Your ref:
Our ref: 22/01022/F
Please ask for: Mrs Lesley Raby
Direct dial: 01553 616818
E-mail: borough.planning@west-norfolk.gov.uk

Details: **Solar PV panels on the roof of 4 holiday lodges at King's Lynn Caravan And Camping Park Parkside House New Road North Runcton Norfolk**

I have received a planning application as detailed above but cannot process it until I receive some more information:

**Title:** LOG CABINS **Drawing 2**

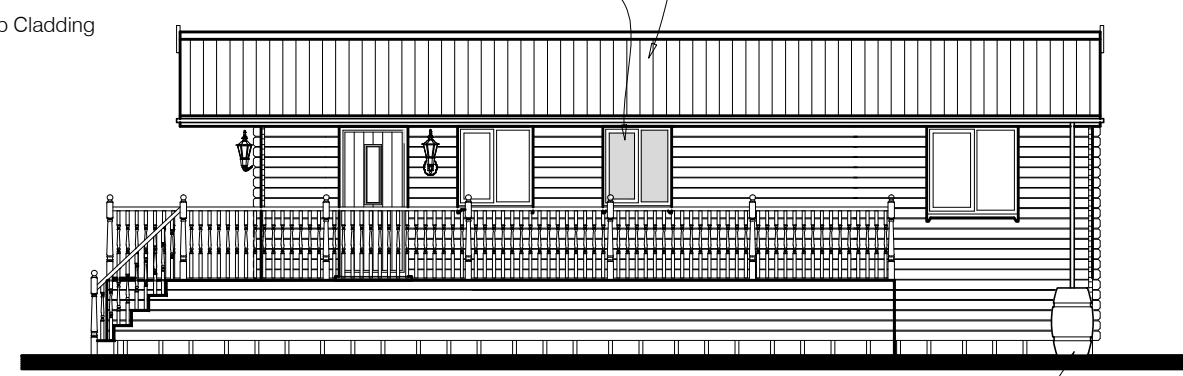
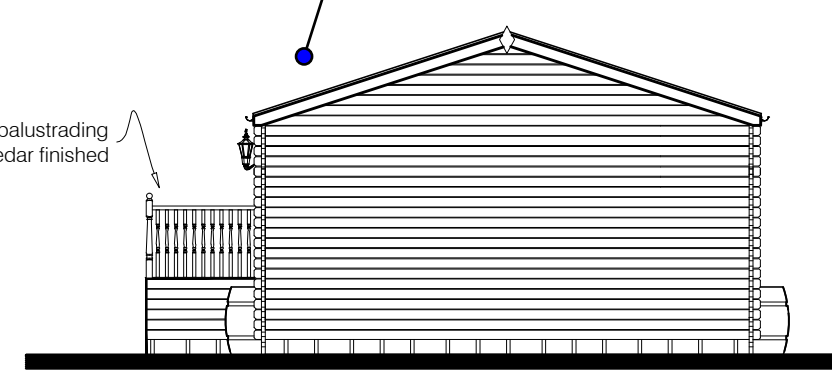
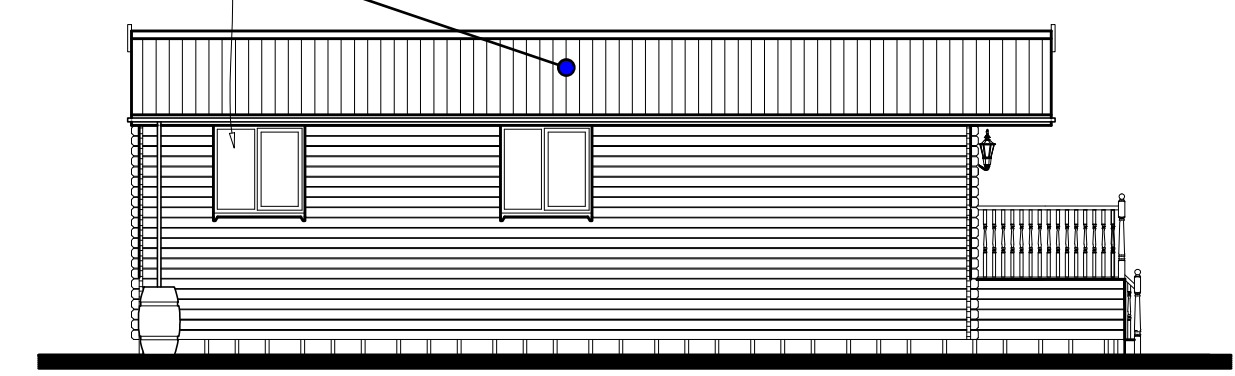
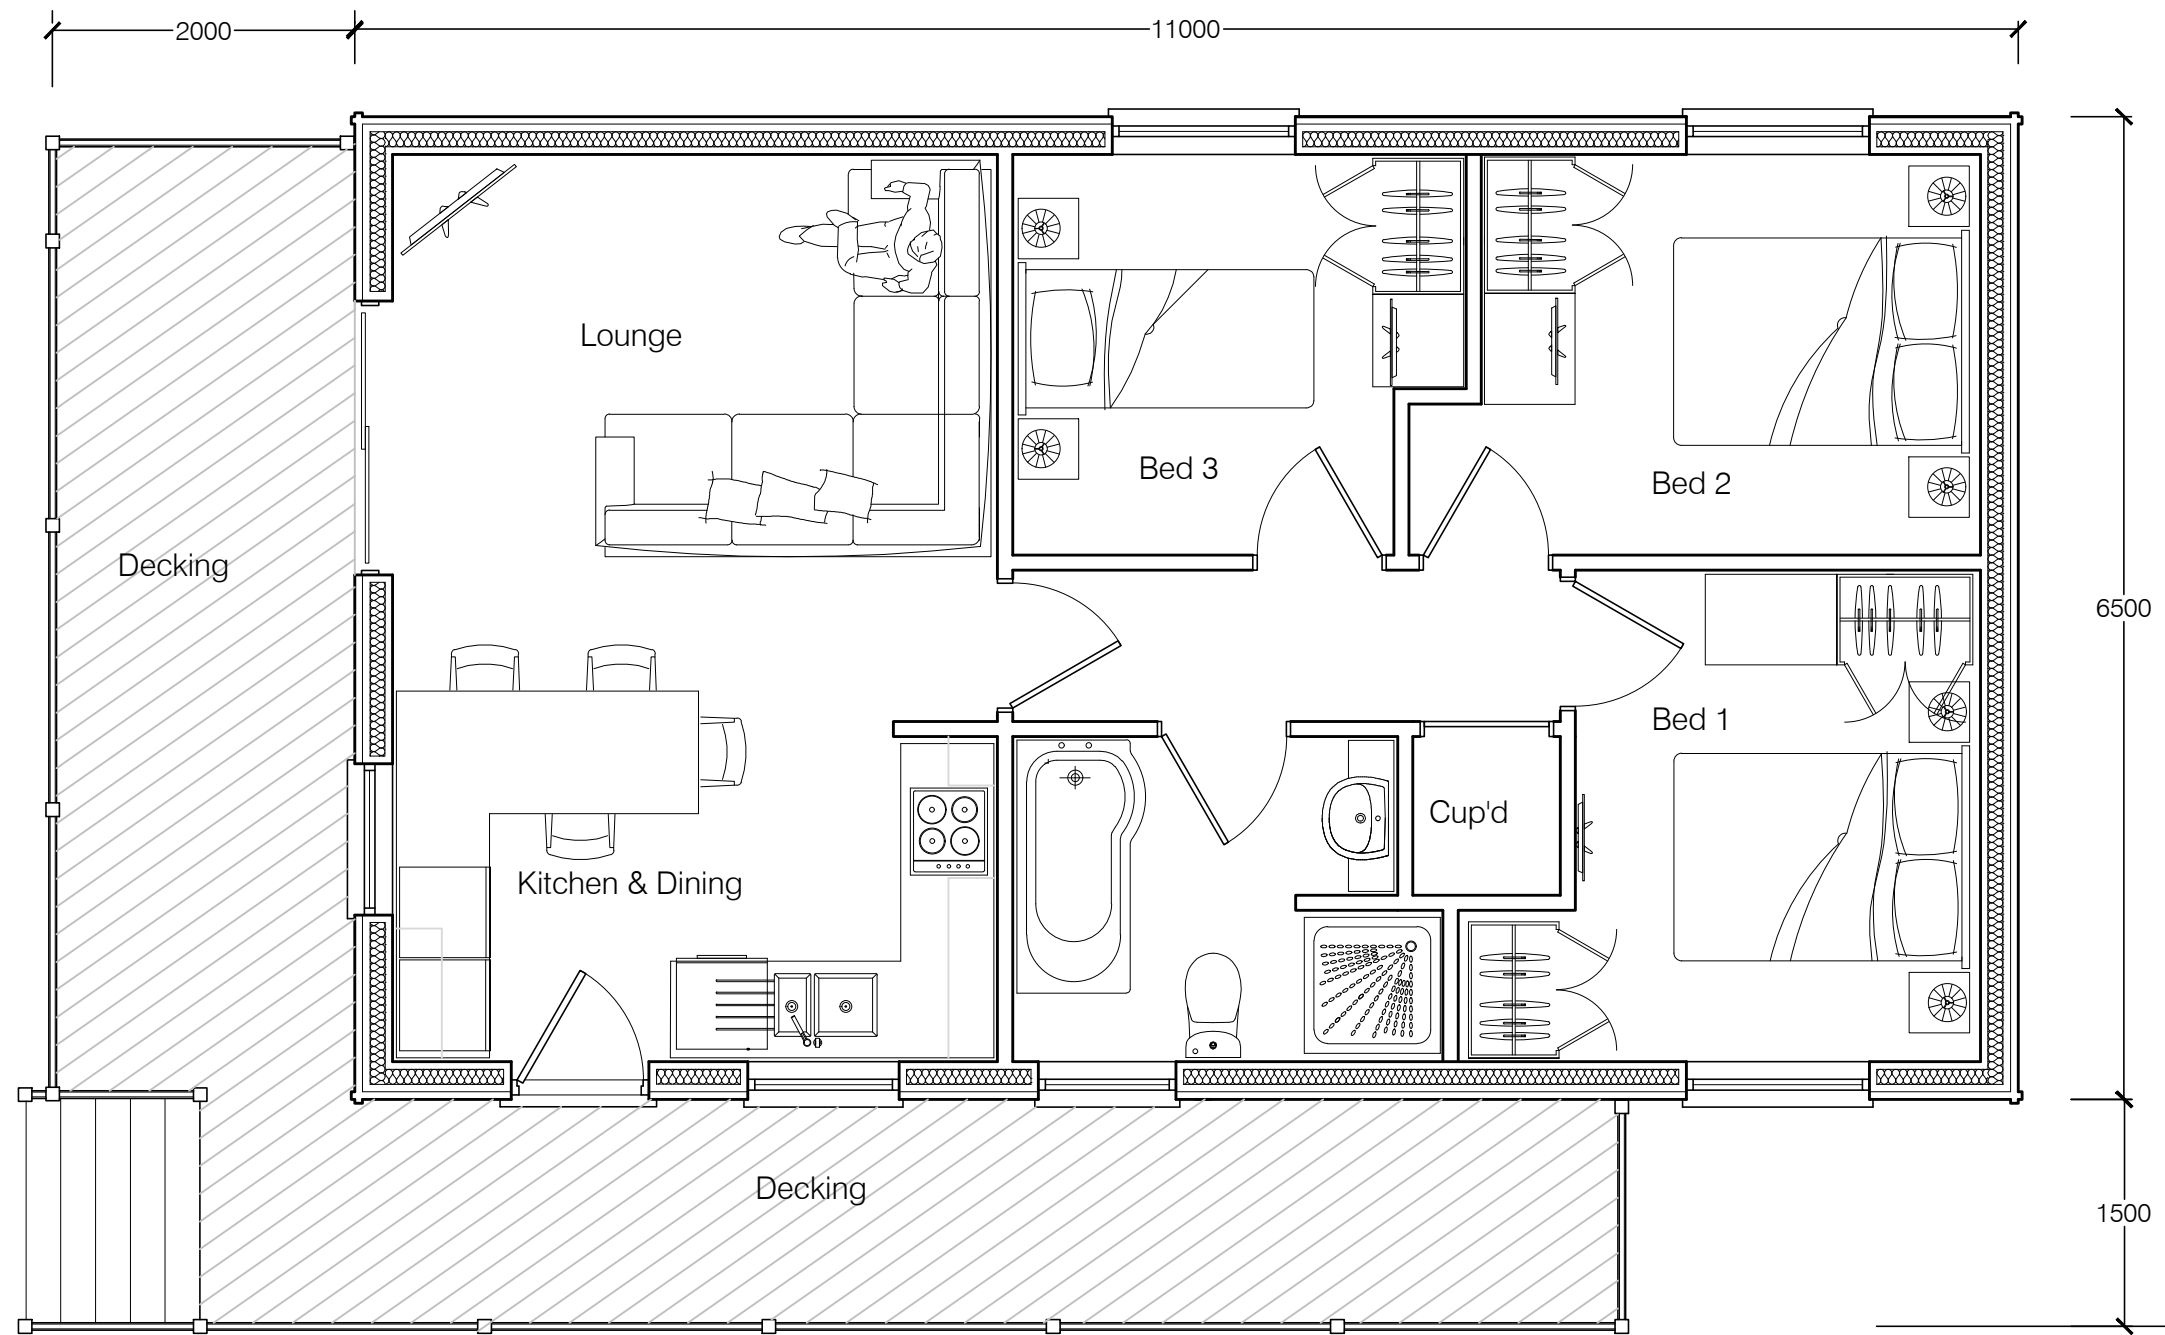
1. Provide a location plan to a scale of 1:1250 with a red line accurately drawn around the application site.
2. Provide a drawing to scale showing the new solar panels in position on the roof slope
3. Provide a scaled drawing showing a section through the solar panels.
